From: Amanda Scholes on behalf of Planning.Responses
Sent: 10 March 2021 10:01
To: Planning Scanning
Subject: FW: Planning Consultation on: Y/15/21/DOC

Thank you for consulting us on this discharge of conditions application. We have the following comments.

Condition 9- surface water drainage strategy

Description of Works: Approval of details reserved by condition imposed under ref Y/88/18/OUT relating to Condition No 8 - drainage strategy, 9 - surface water drainage, 10 - maintenance & management of surface water drainage and 11 - broadband.

Drawing Title
DRAINAGE LAYOUT - PLOTS 24-32
38 UNIT SITE - SHEET 2 OF 6

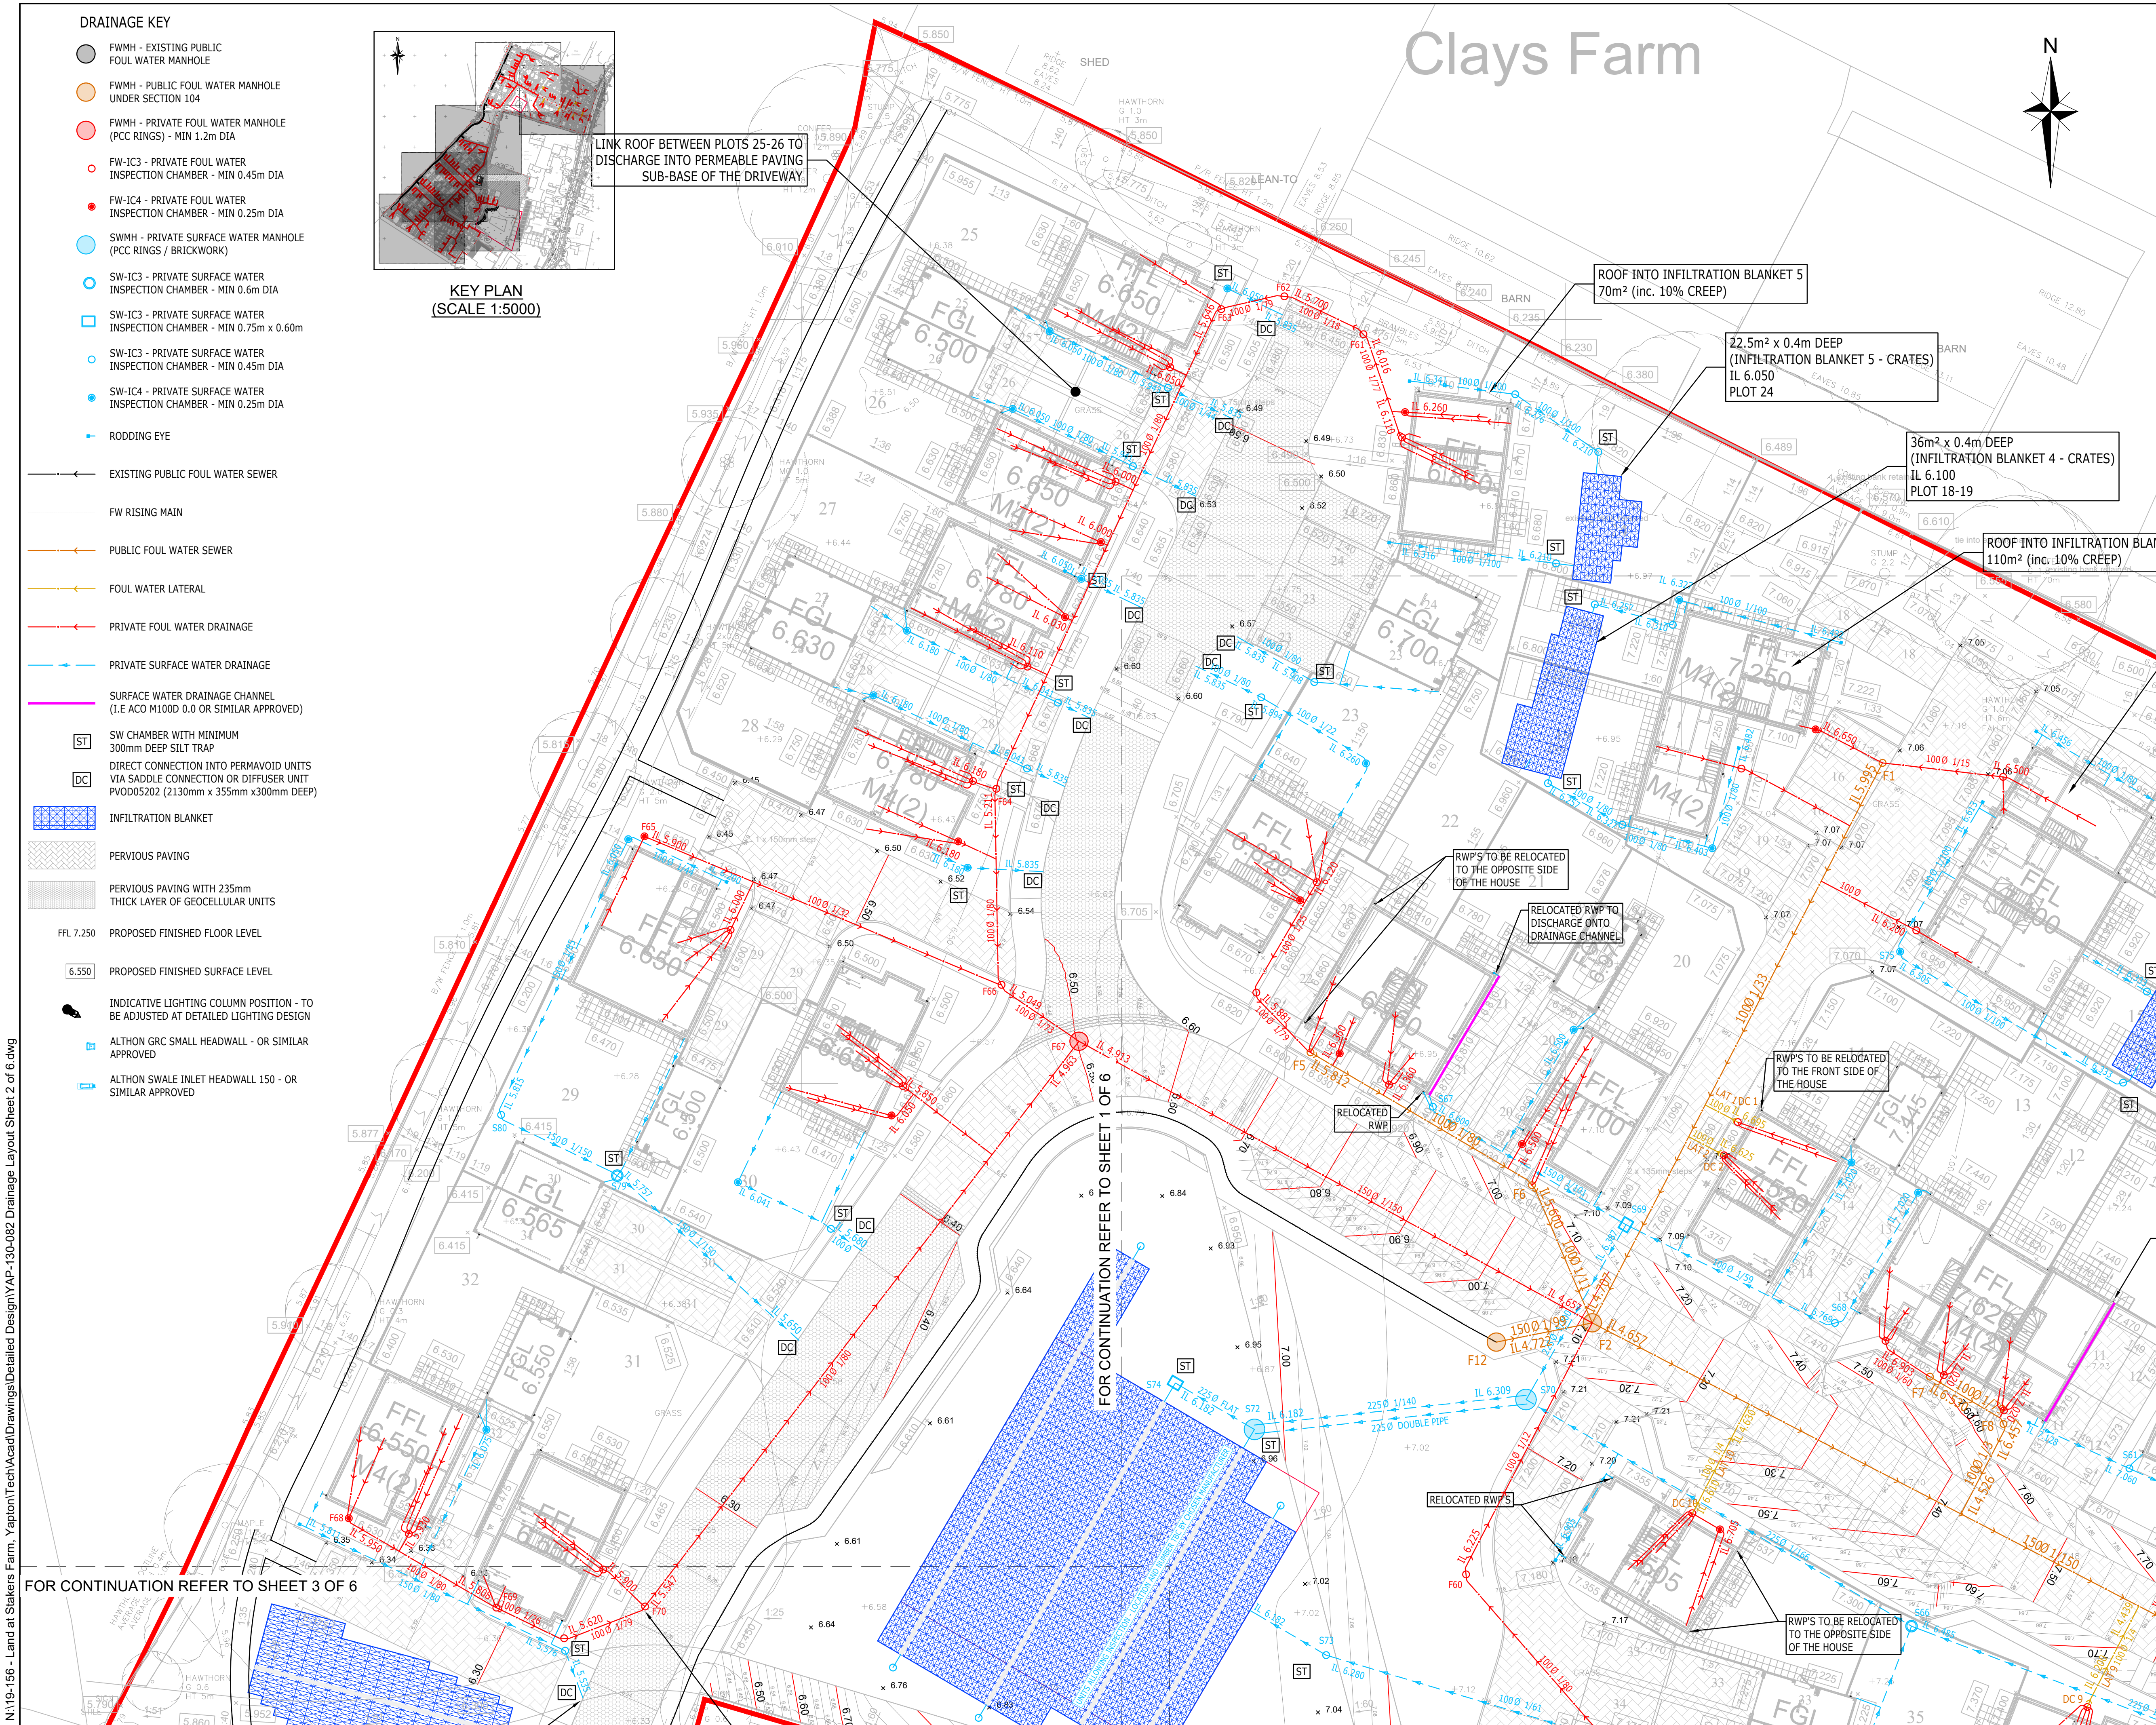
3. Please provide cover levels at crates to demonstrate that adequate cover depth is being provided. Proposed finished ground levels are indicated on drawings YAP-130-081C2 and YAP-130-082C2 and designed to provide minimum 300mm of cover – which is the cover suggested by the geocellular units manufacturer (i.e. Wavin and its Aquacell product). *Wavin state that 0.3m cover is required in landscaped areas, but 0.5m is required where ride on mowers may be used. In the public open space areas it is evident that ride on mowers are highly likely to be used, therefore the cover depth currently provided is insufficient for these crates. Additionally they state that additional protection will be required where construction plant is to be used, please detail how crates will be protected during construction.*

11. Road type 2 which drains plots 23, 25-27 appears to have incoming invert levels at the base of the structure, rather than above the 1 in 10 year plus cc water level. Please revise. Drainage design updated. Please see drawings YAP-130-082C2 and YAP-180-031C2. The actual connection into the Permavoid must be constructed at the base due to the proprietary saddle connection fitting part, however the surface water (SW) system is designed so the last SW chamber (silt trap) is above the 1 in 10 years plus cc water level within permeable paving system, i.e. SW system is not lower than 5.995m AOD, which is a water depth of 0.16m (please see Road 2 with plots 23,25-28_1 in 10 yrs with CC_Rev_B calculations) for the storm design event added to the permeable paving base level of 5.835m AOD.

The same will apply to Road 3, where final connection into Permavoid must be constructed at the base due to the proprietary saddle connection fitting part. In this instance the water depth for the 1 in 10 yrs plus cc event is 0.288m (please see Road 3 plus plots 29-32_1 in 10 yrs with CC_Rev_C calculations) and with permeable paving sub-base level of 5.430m AOD (measured at the downstream end of Road 3, please see drawing YAP-130-028C1) results in the design water level of 5.718m AOD. We have designed last SW chamber (silt trap) prior to Permavoid connection to be not lower than this level and downstream pipe do not have any additional connection thus serves as connection conduit only with the actual SW system not

being subjected to surcharge during the 1 in 10 yrs plus cc event. *Unclear on where any alterations to design have been made, incoming invert levels and formation levels appear the same.*

16. *Cover levels of MH1 (S61), MH3 (S63), MH5 (S65) MH8 (S68), MH 9 (S69) are inconsistent between calculations and layouts. Please correct to ensure consistency.*

17. *Please clearly show catchpits upstream of all connections into infiltration devices, SWMHs which are catchpits should be clearly identified on both layout plans and manhole schedules.*
